CITY OF ALBUQUERQUE

Re: TI @ 6700 Bluewater Rd NW
6700 Bluewater Rd NW
30-Day Temporary Certificate of Occupancy
Transportation Development Final Inspection
Engineer's/Architect's Stamp dated 4-15-21 (K10D062)
Certification dated 8-23-21

TRAFFIC CIRCULATION LAYOUT

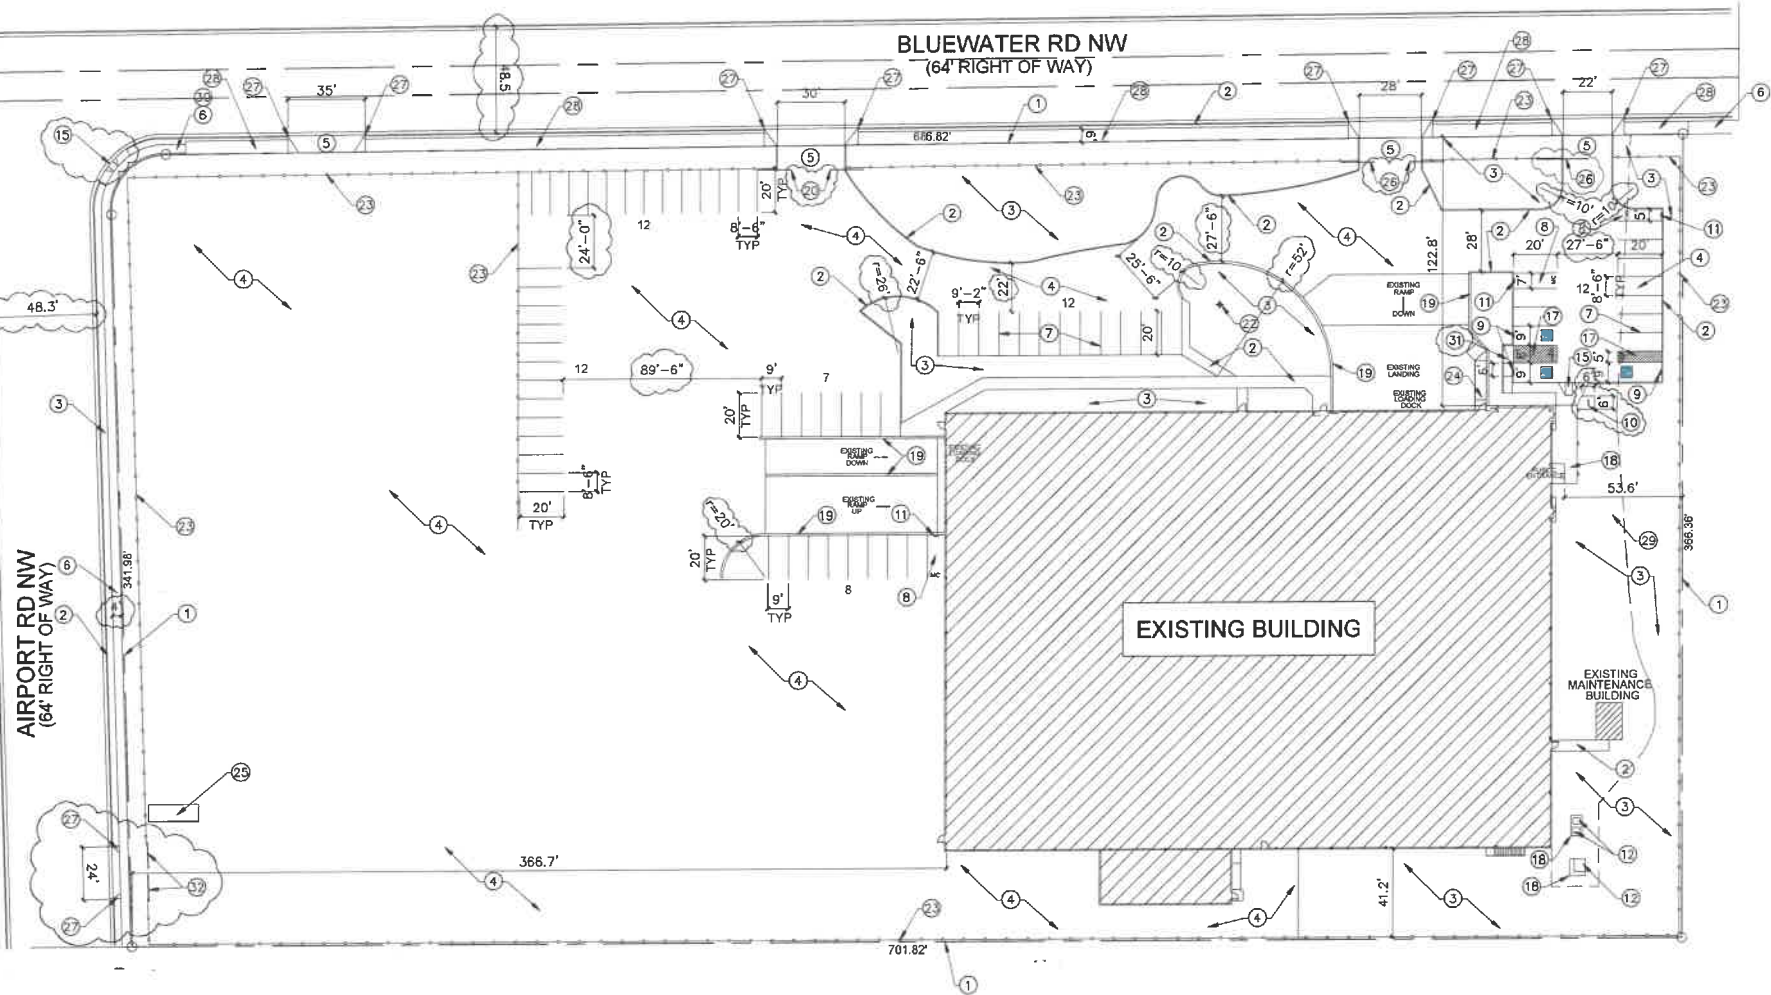
- The ADA access aisle shall have the words "**NO PARKING**" in capital letters, each of which shall be at least one foot high and at least two inches wide, placed at the rear of the parking space so as to be close to where an adjacent vehicle's rear tire would be placed. (66-1-4.1.B NMSA 1978)
- Please complete landscaping & remove construction materials and debris from site.
